## MEMORANDUM

**TO:** Jean Fraser, Planner  
**FROM:** David Senus, P.E. & Ashley Auger, E.I.T.  
**DATE:** May 15, 2014  
**RE:** 421 Warren Avenue, Final Level III Site Plan Application

Woodard & Curran has reviewed the Final Level III Site Plan Application for the proposed 6-unit commercial complex located at 421 Warren Avenue in Portland, Maine. The project consists of constructing a single-level 25,000 SF industrial building along with associated site improvements, which will result in approximately 56,252 SF of new impervious area. The project is being reviewed for compliance with City of Portland Level III Site Plan requirements and under the City's delegated review authority for Chapter 500, Stormwater Management Law.

**TO:** Jean Fraser, Planner  
**FROM:** David Senus, P.E. & Ashley Auger, E.I.T.  
**DATE:** March 3, 2014  
**RE:** 421 Warren Avenue, Preliminary Level III Site Plan Application

SHEET TITLE **GRAVEL WETLAND DETAILS**

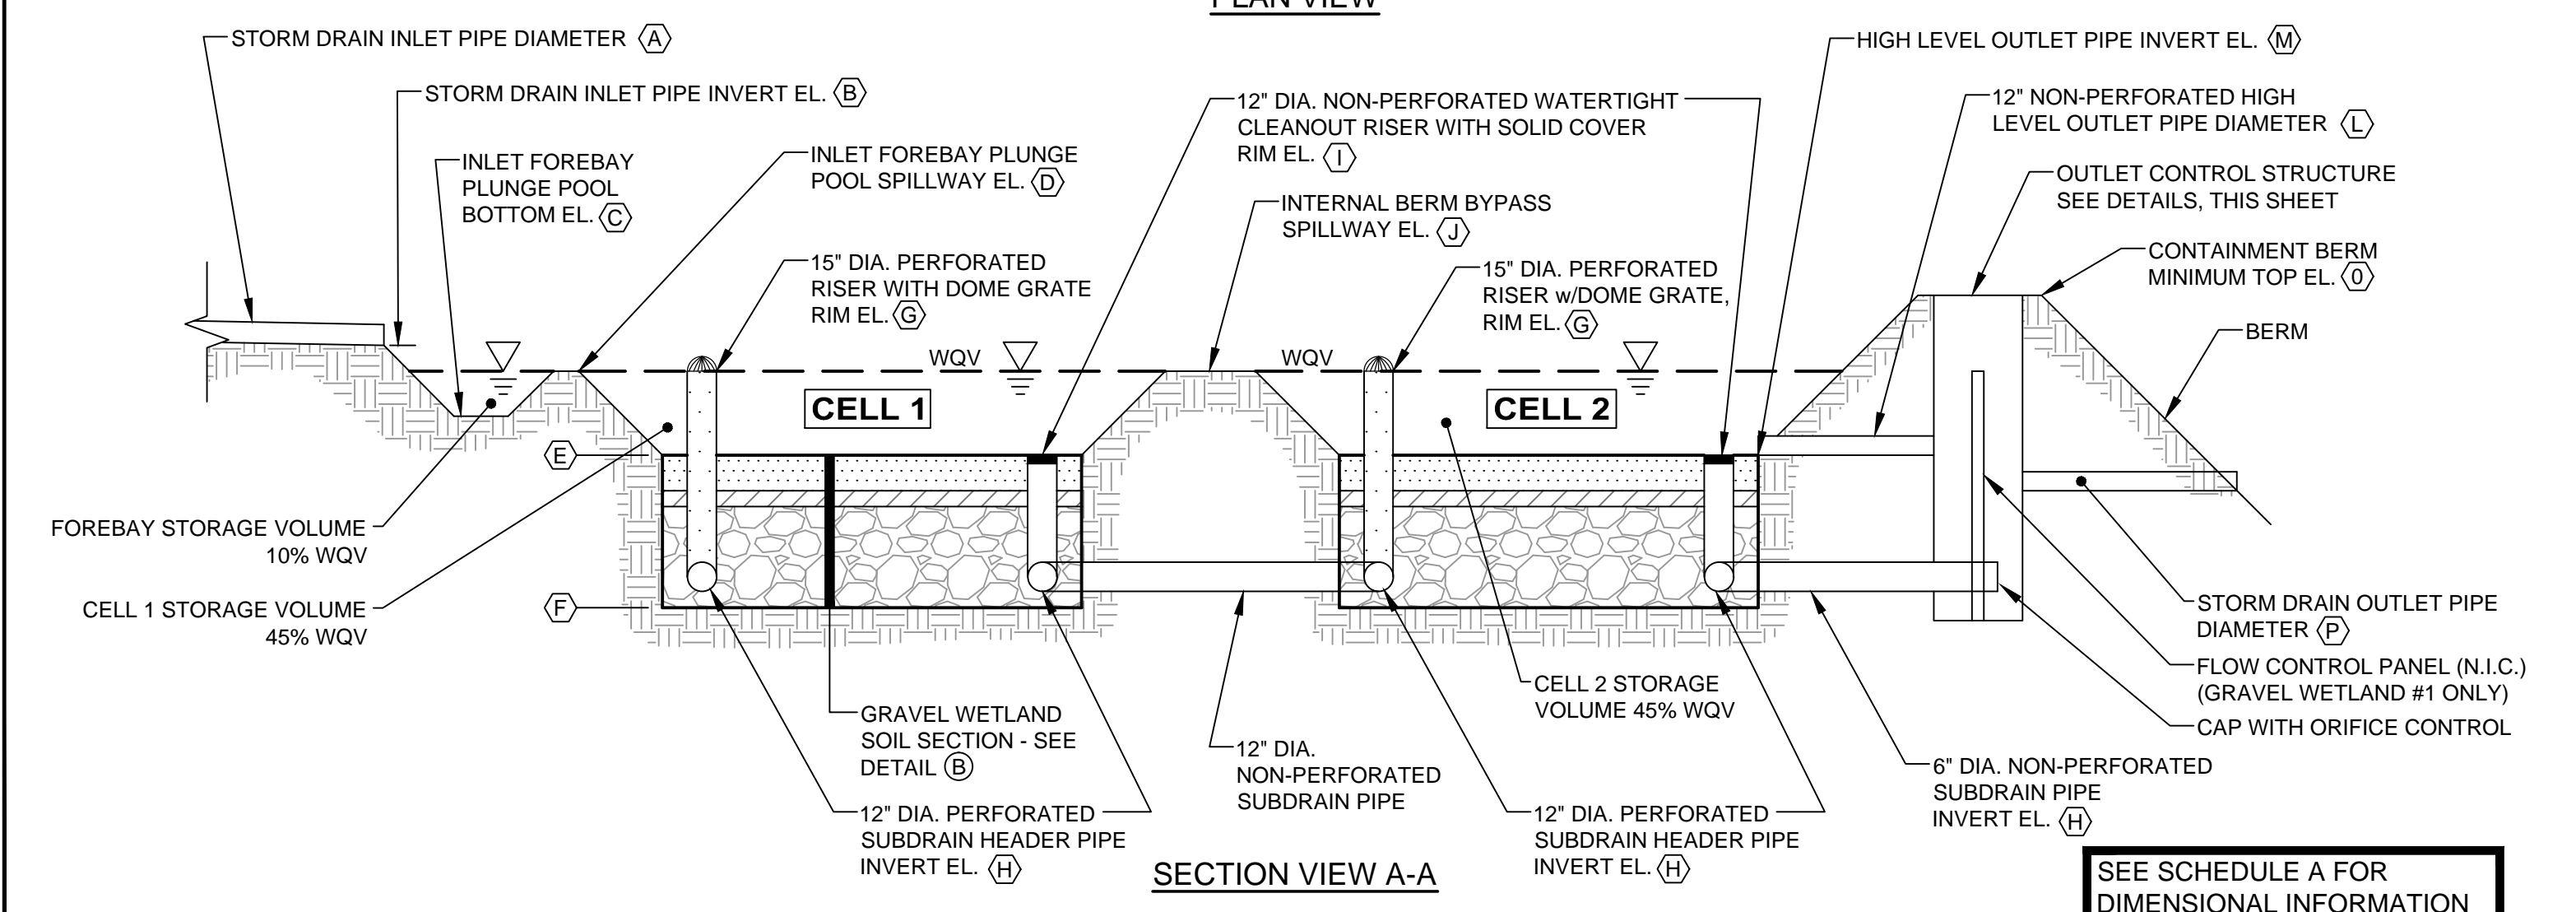
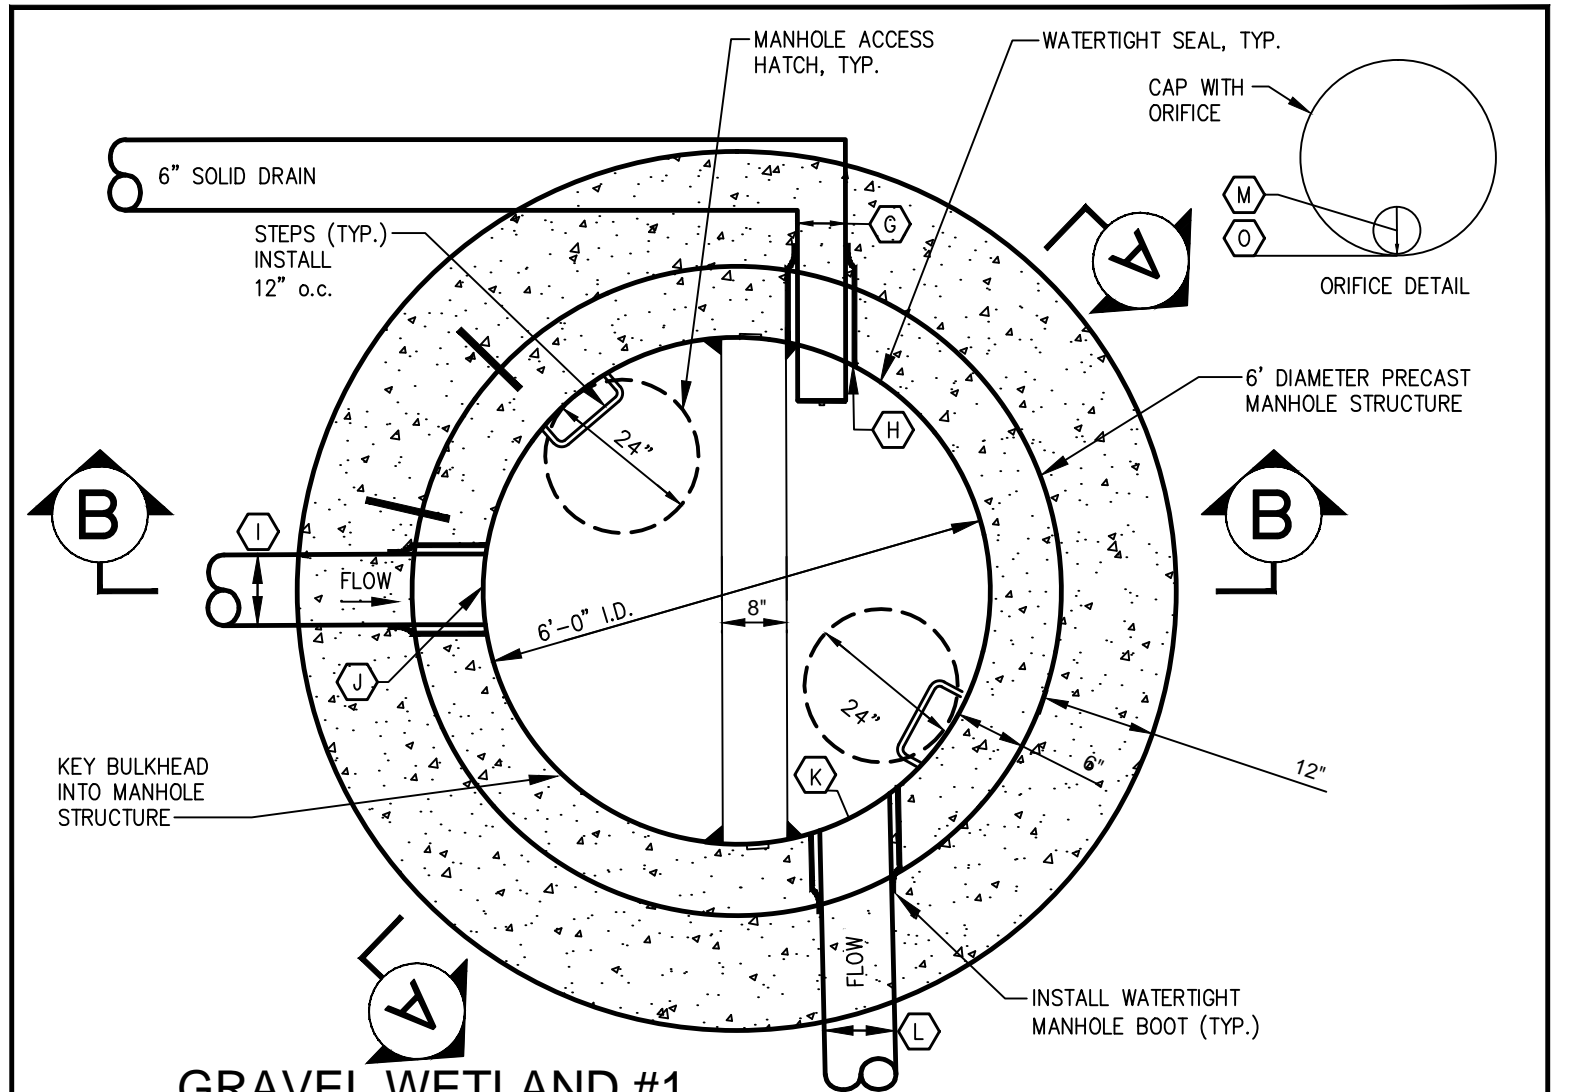
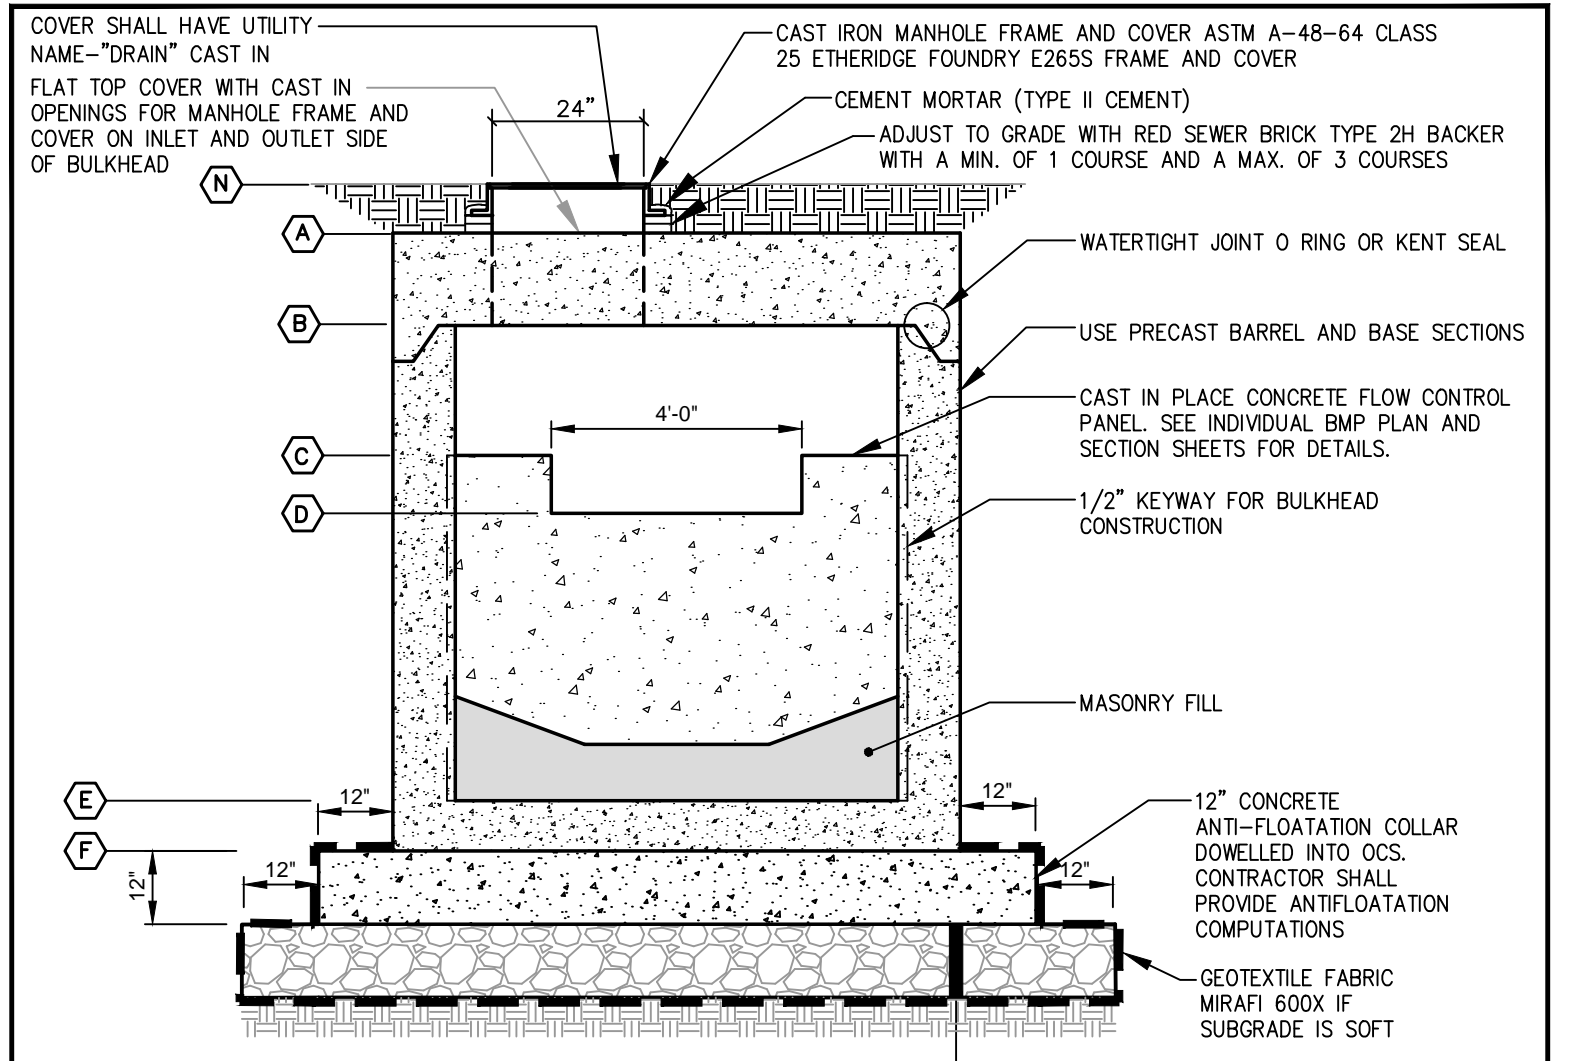
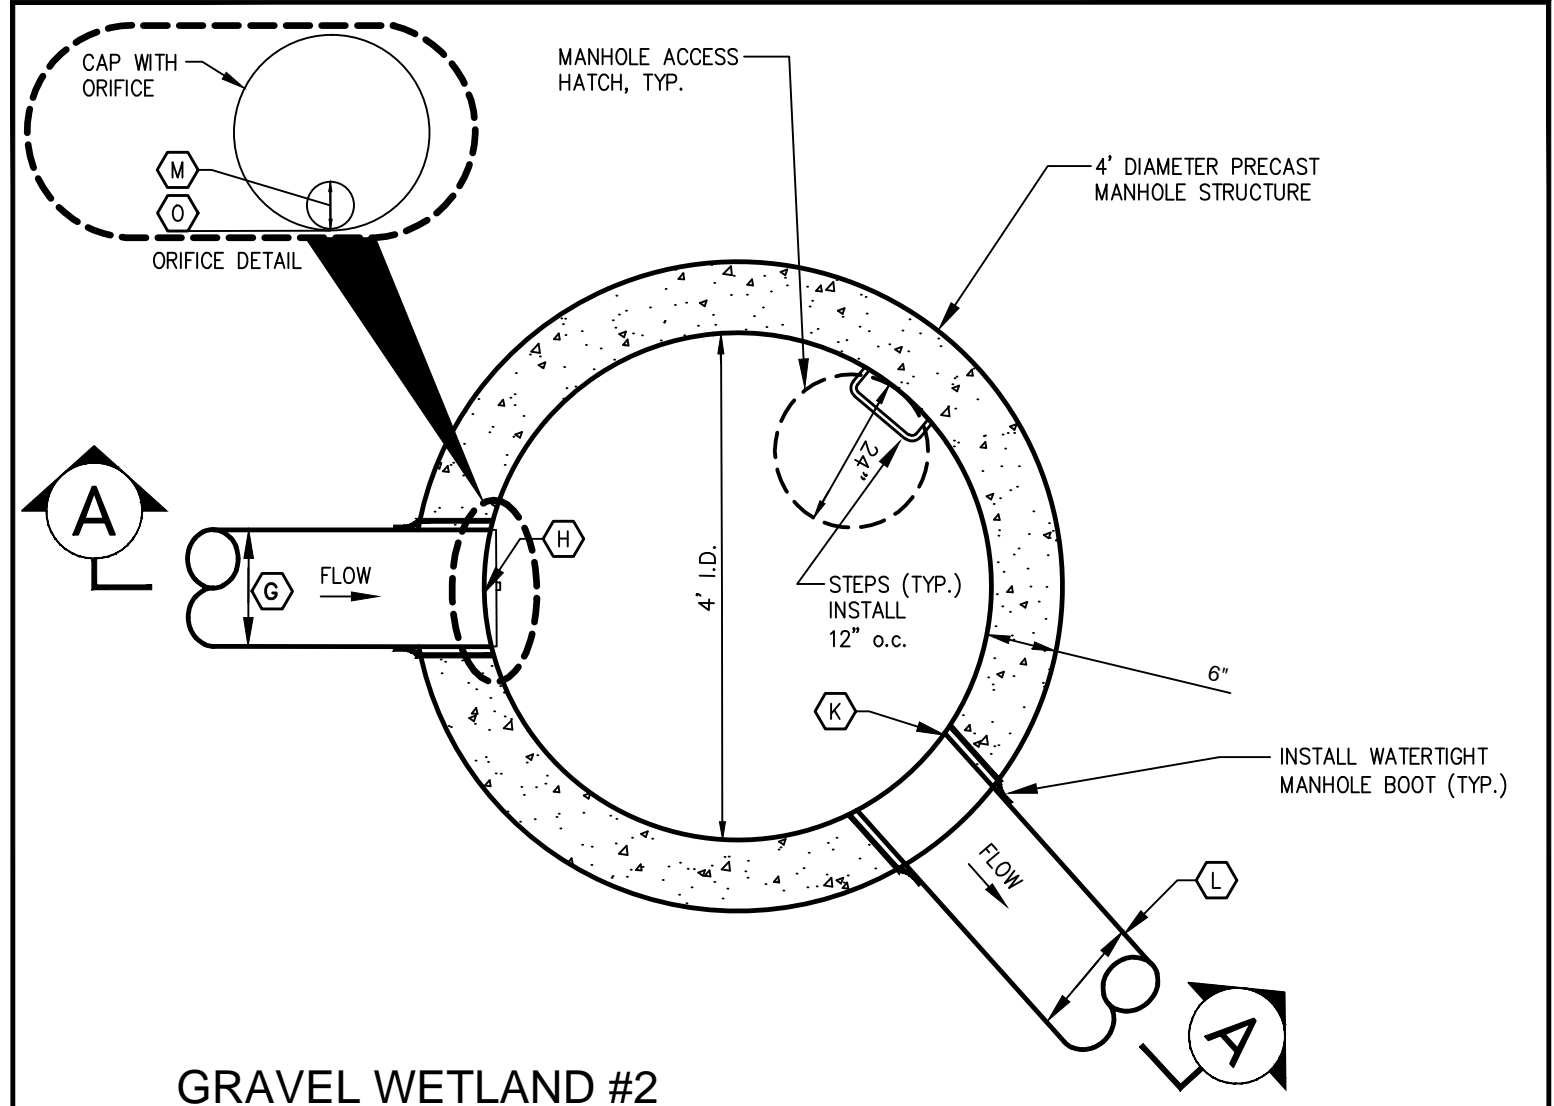
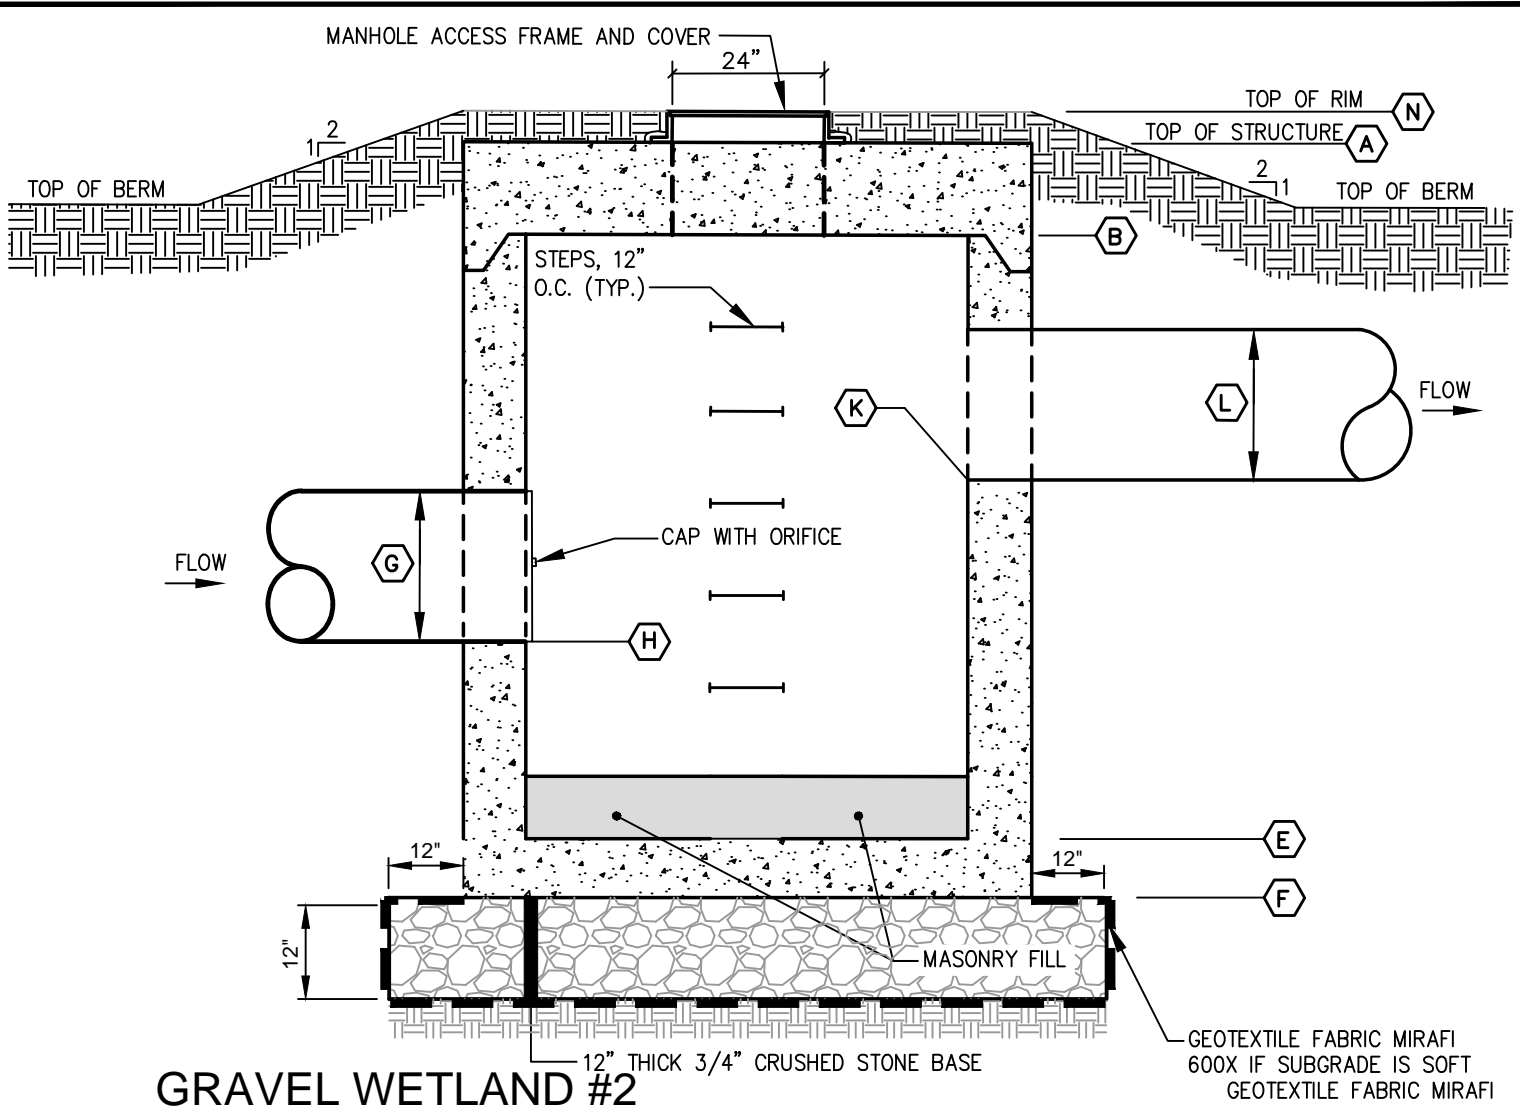
- e) As noted on the plans, the Applicant intends to add outlet elevation information to the outlet control structure details for both gravel wetlands as part of the final submittal. Without this information we cannot verify the routing or model inputs for Pond 4P (GW2) or Pond 5P (GW1). When the outlet control structure elevations are incorporated into the final submittal, please revisit or provide explanation on the routing methodology for GW1 & GW2 in the HydroCAD model; we are unable to follow the routing as currently presented.

- b) The Applicant has submitted drawdown calculations for sizing the gravel wetlands' outlet control structure orifice control devices; however, the orifices do not appear to be specified on the design plans/details. The Applicant should clarify with the final design package.
